RE: Letter of Intent– MVEA Eastonville 2

Mountain View Electric Association, Inc (MVEA) will be constructing a 12.5 kV underground electrical distribution feeder line running along the Eastonville Road from Latigo Boulevard to Londonderry Drive. The underground installation will be approximately 2.7 miles in length and will begin at the Meridian Electric Substation near the intersection of Eastonville Road and Latigo Boulevard. The installation will run south parallel to Eastonville Road offset a distance of approximately 55' from the road. The line terminates south of Londonderry Drive where it will tie-in to existing conduit.

GRADING, EROSION, & SEDIMENT CONTROL PLAN

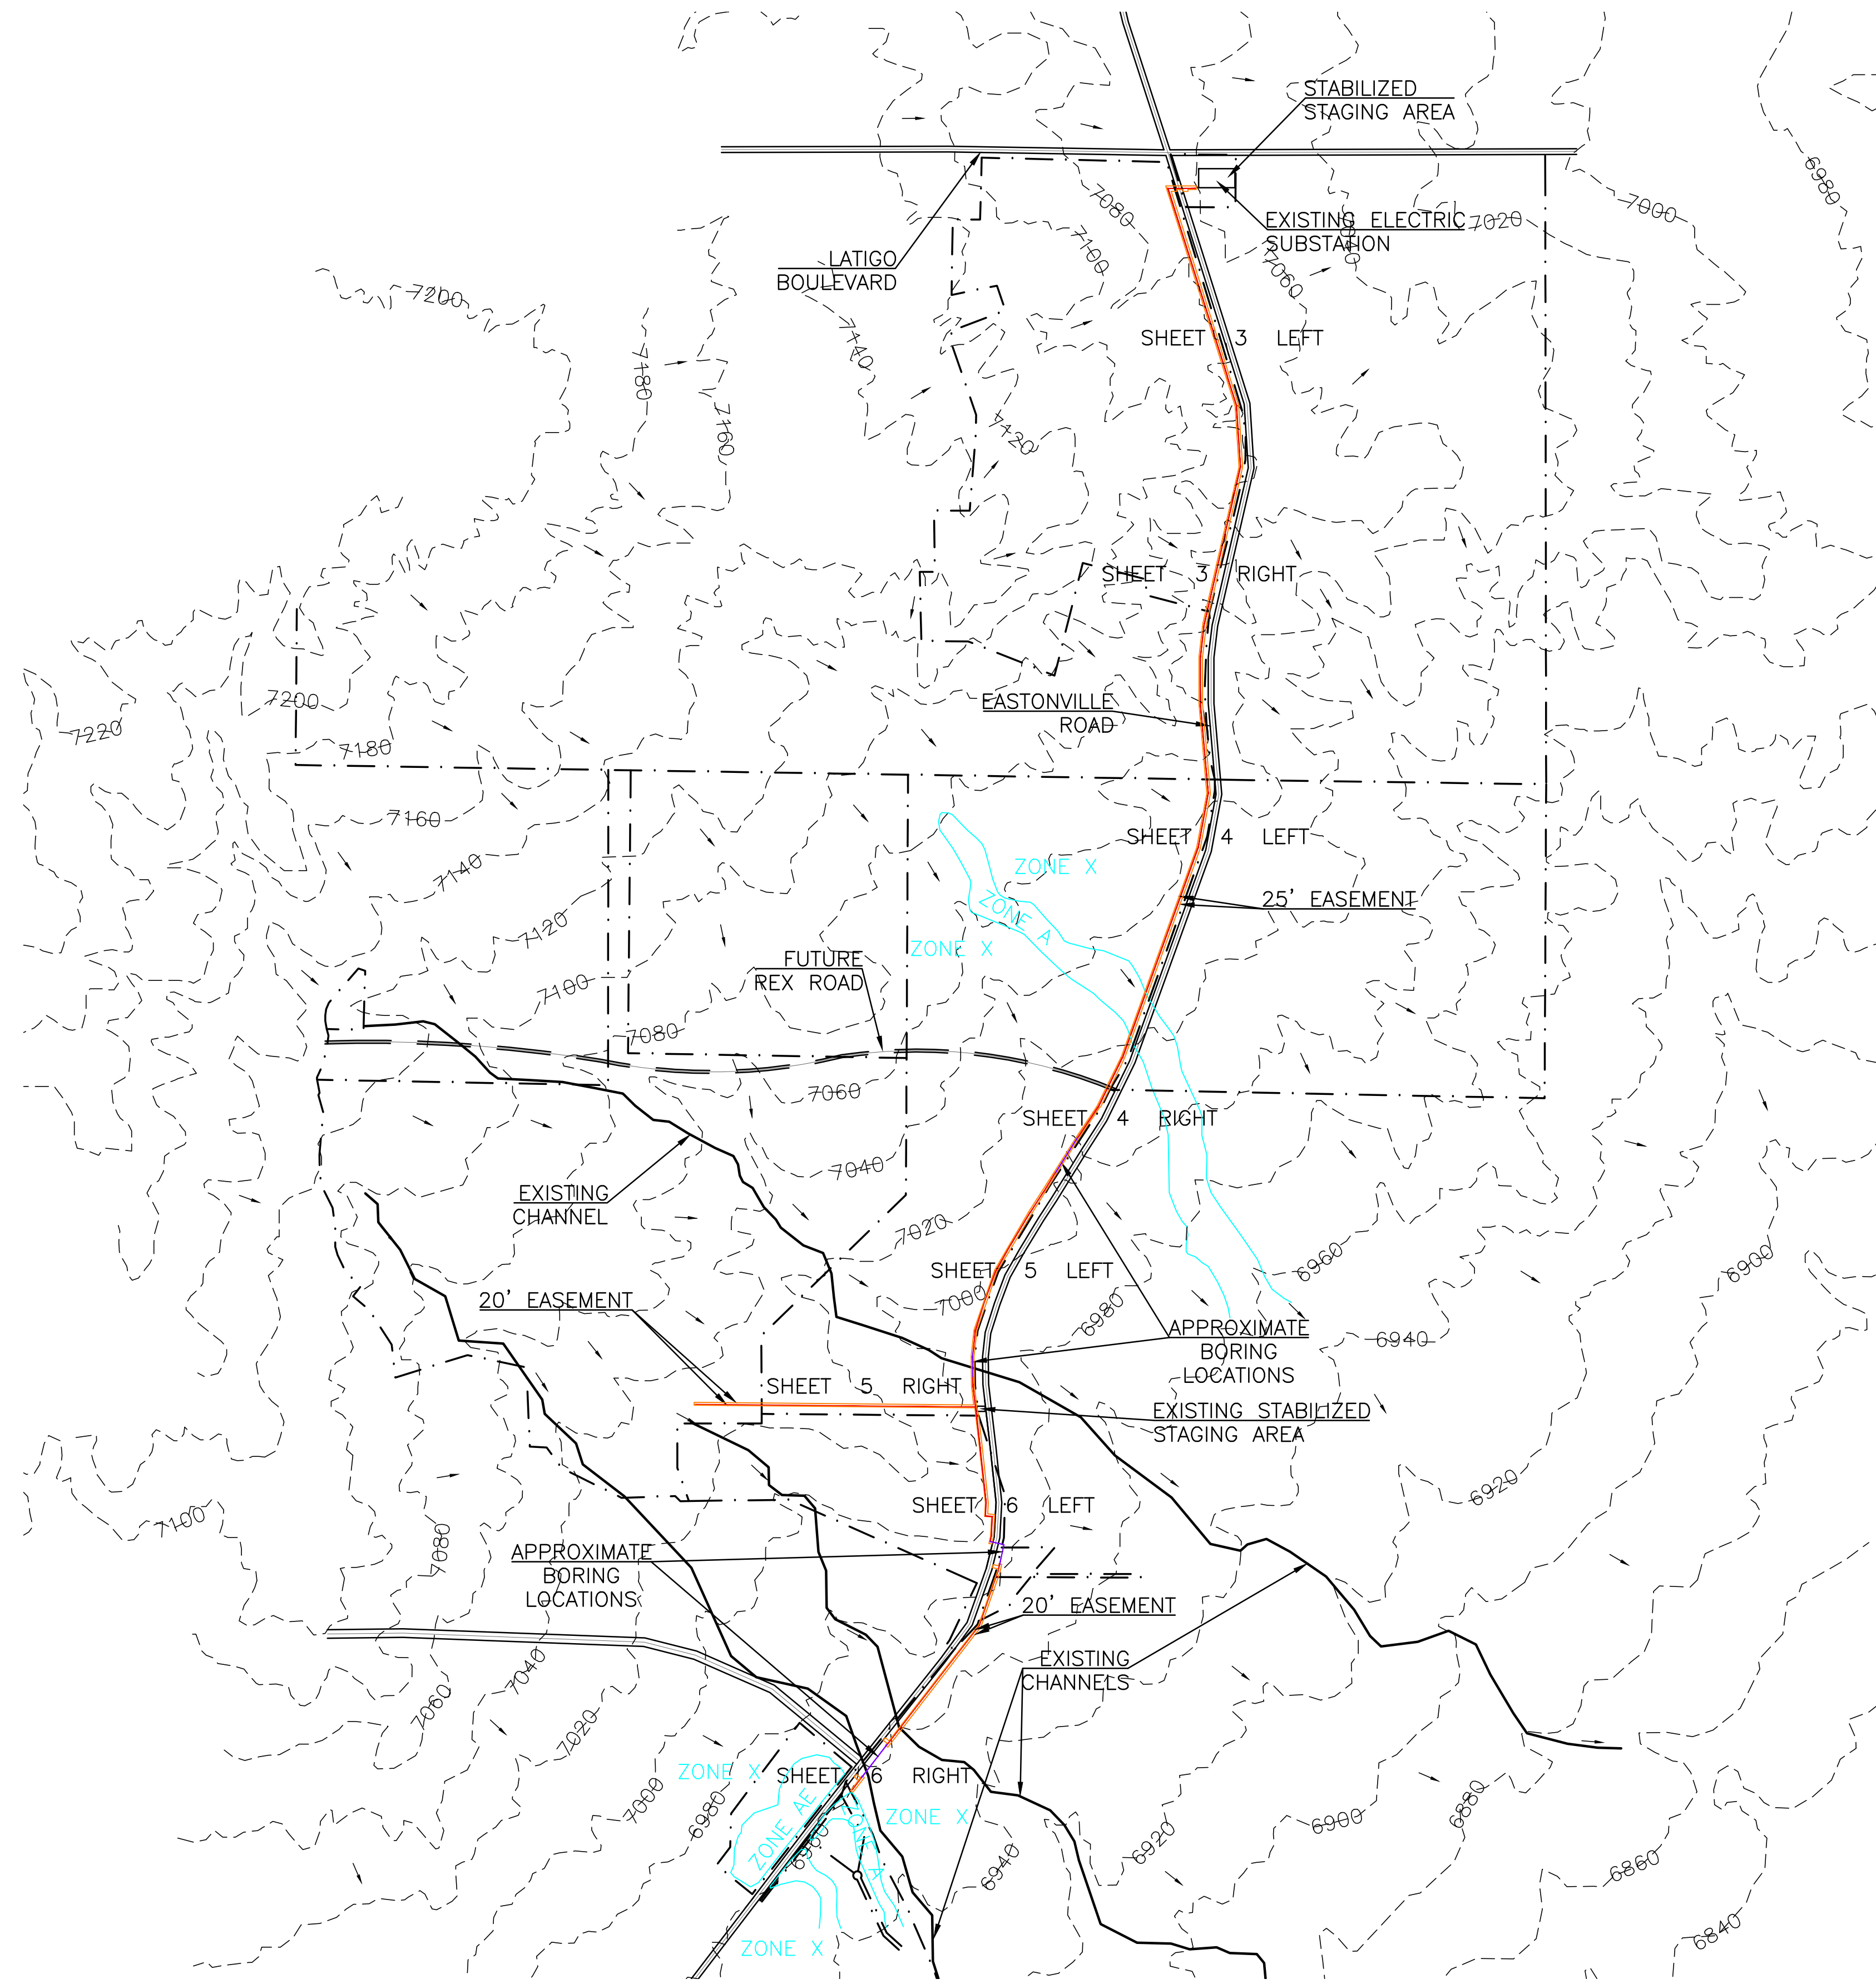
Please confirm the proposed activity will not adversely impact adjacent properties or existing drainage patterns.

- Please provide the total area of land disturbance and the scope of work that sums to the total area of land disturbance.
- Applicant is required to apply for a Work-in-ROW permit from El Paso County Department of Public Works since Eastonville Road is a county maintained road. Please confirm applicant will/has applied for a Work-in-ROW permit.
- FYI: Per ECM K.1.8 all disturbed road gravel surfaces shall be repaired to ECM standards listed in the section above.
